Project Application for Mixed Use Development

45-47 Macquarie Street and 134-140 Marsden Street, Parramatta

MP09_0167 MOD4

Secretary's Environmental Assessment Report
Section 75W of the
Environmental Planning and Assessment Act 1979

SOUTH ELEVATION

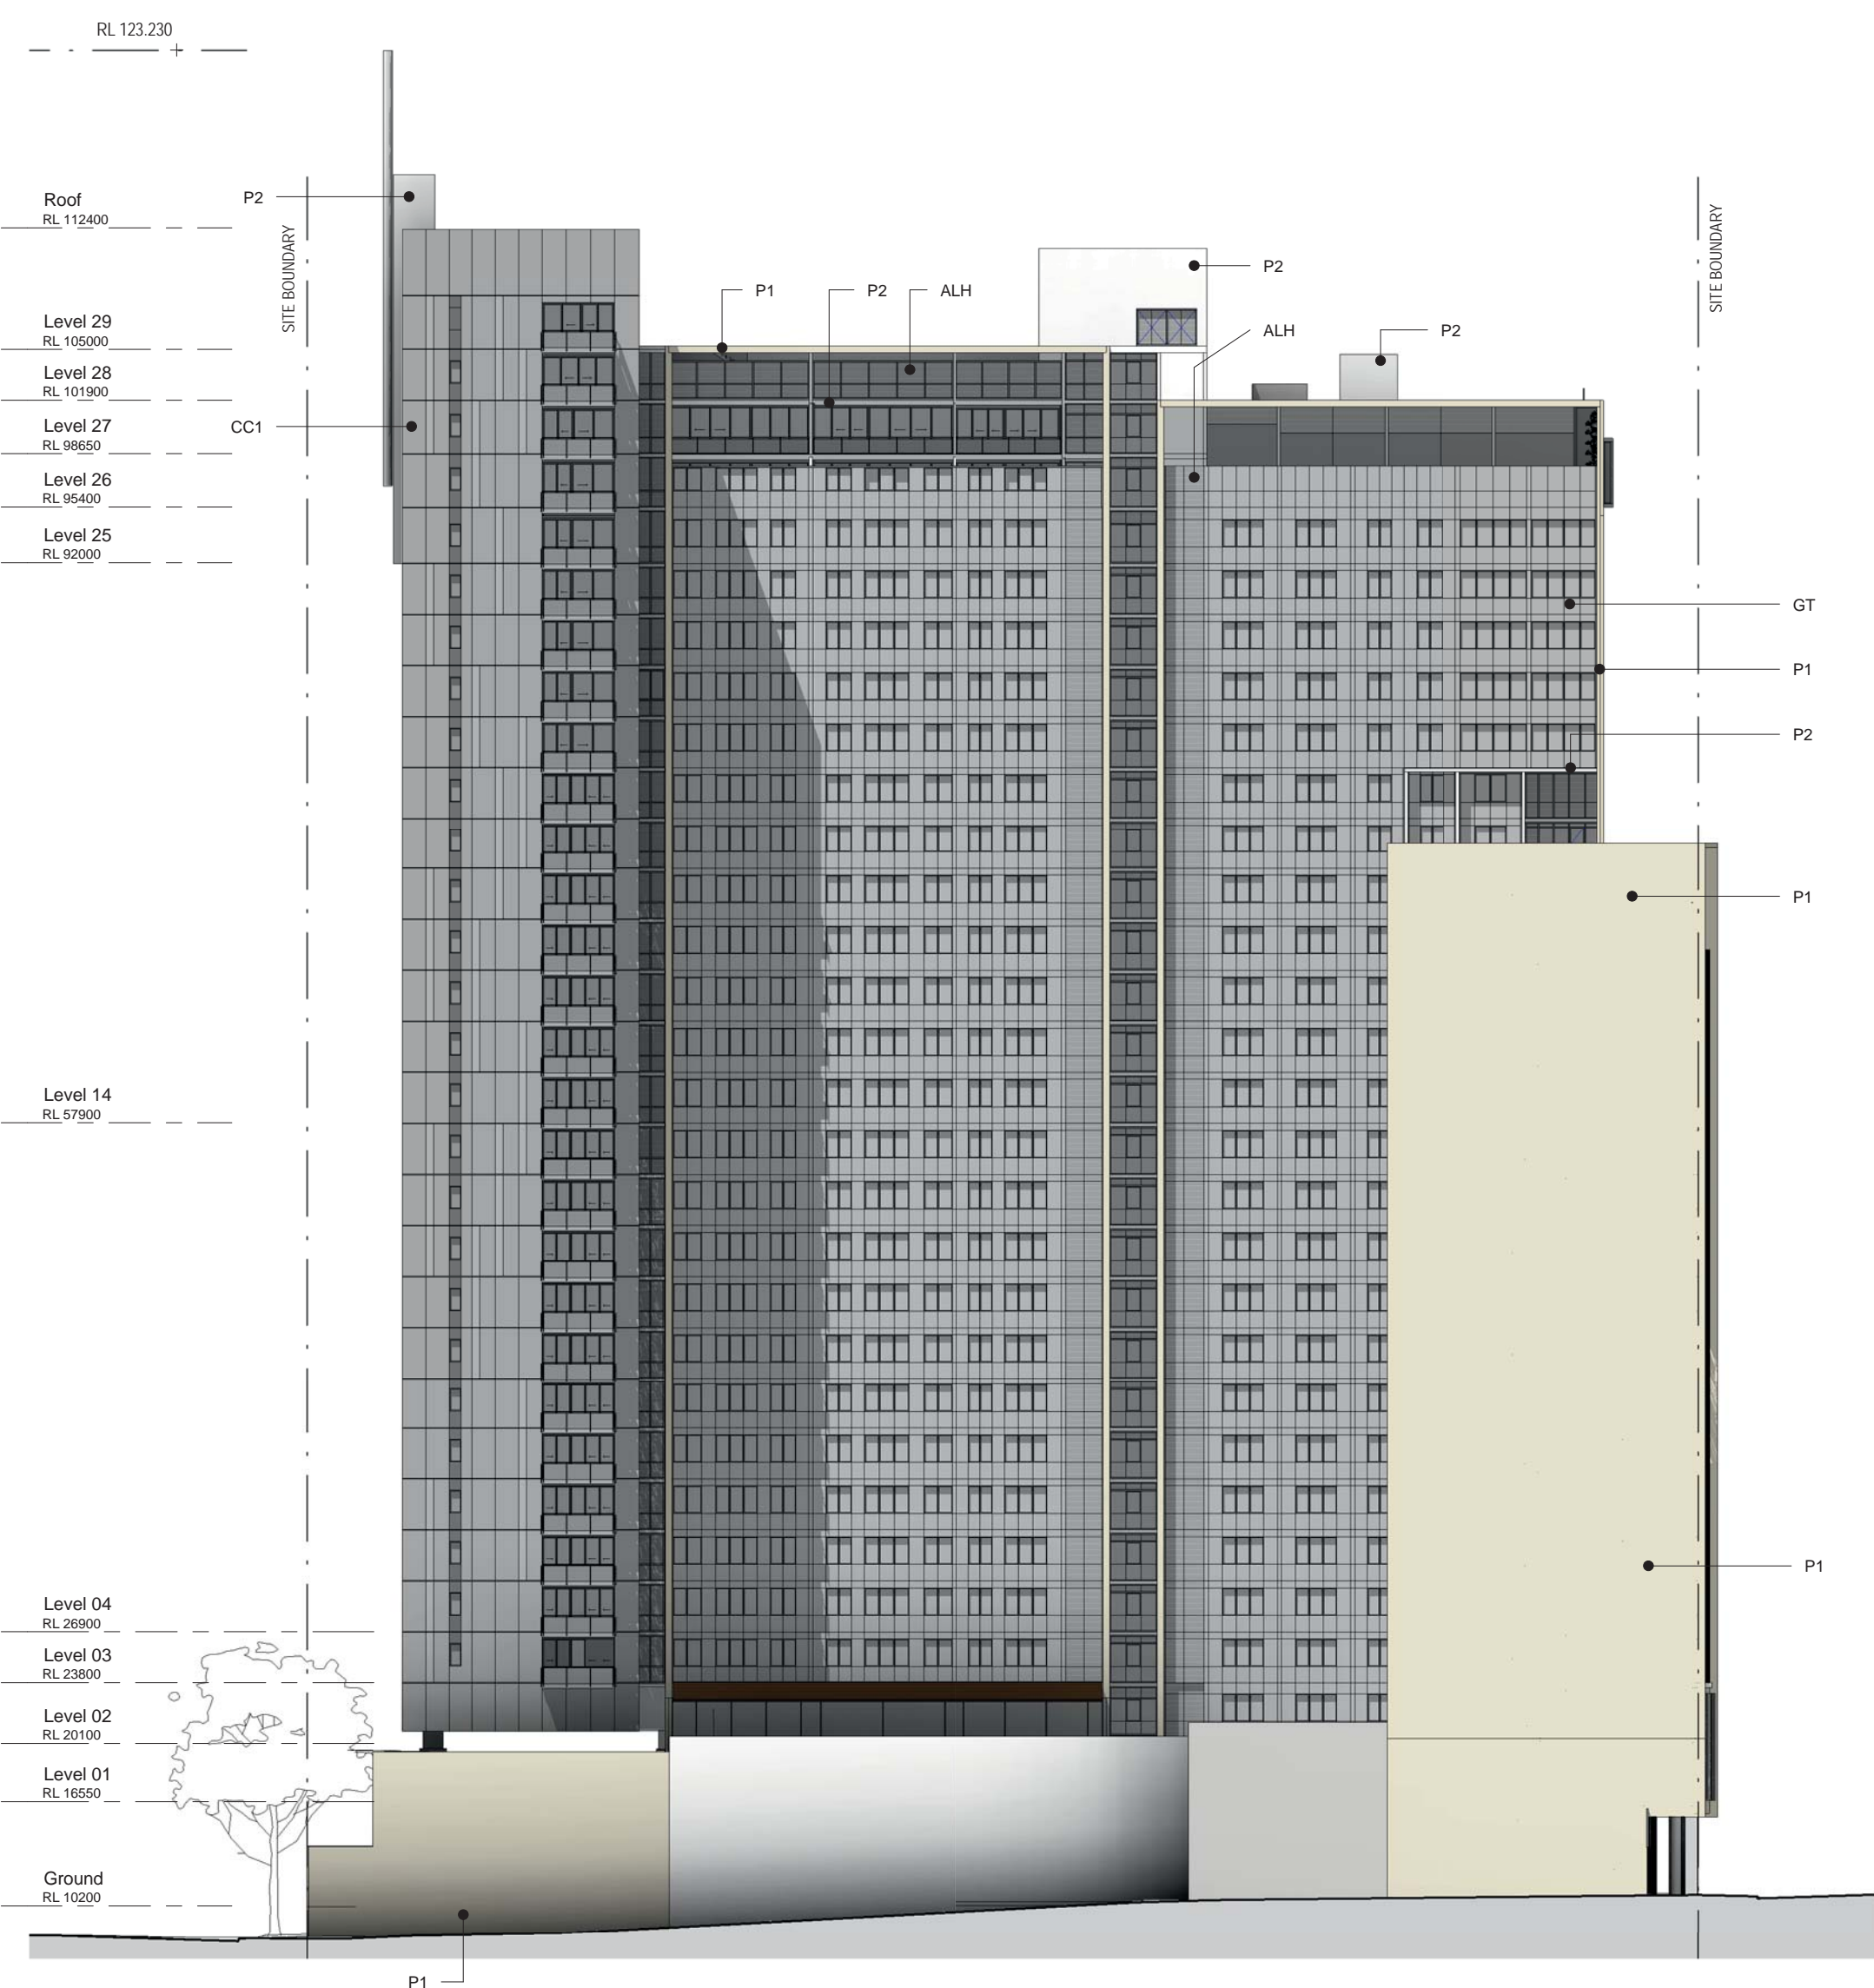
Council raised concern that the design of the Hunter Street elevation of Block D lacks compositional clarity and the distinction between the taller and shorter elements of the development has been diminished.

In response the proponent amended the proposed Hunter Street elevation of Block D by setting back the top three floors, dividing the Hunter Street elevation into three vertical parts and providing dark glazing within the central part of the elevation to mimic the visual break / gap between Blocks B and C on Marsden Street.

The Department considers that the revised architectural composition of the Hunter Street elevation is adequate for the following reasons:

- the amendments to the façade have provided additional articulation that emphasises the vertical proportions of the building, which in turn has reduced its perceived bulk and mass;
- the three different architectural approaches to the lower, middle and upper components of the elevation provide for visual interest;
- the inclusion of darkened glazing centrally within the facade provides additional contrast and strengthens the overall verticality of the elevation; and
- the setback upper three storeys are suitably recessive and breaks down the perceived scale of the building.
